Recommendation Report for Planning Permission for Works or Extension to a Dwelling

REF NO: FG/135/21/HH

LOCATION: 23 Ocean Drive
Ferring
BN12 5QN

PROPOSAL: Conversion of roofspace to habitable use to a chalet bungalow to include a flat roof dormer

Side Elevation (North West Facing)
(Scale 1:100)

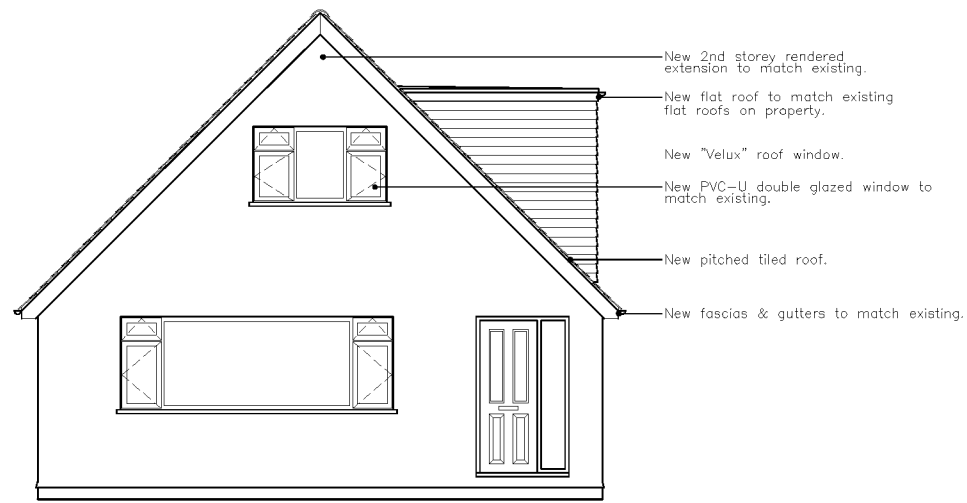
Concerns have been raised by the neighbours to the North. Whilst it is agreed that a window to this elevation will give a perceived sense of overlooking; the fact that the window serves the staircase, it is felt that in practice, this will not occur. However, during the course of this application the applicant has decided to alter the proposal to include a high-level slit window to alleviate the concerns of the neighbour.

A number of new velux windows are proposed on the north west facing elevation of the property facing the neighbour to the north. To avoid any harmful overlooking these windows will be conditioned to be fixed shut and obscure glazed up to 1.7m from finished ground floor.

- 3 The proposed 10 velux windows to the side elevation (north west facing) will be obscure glazed and fixed shut up to 1.7m from the finished ground floor.
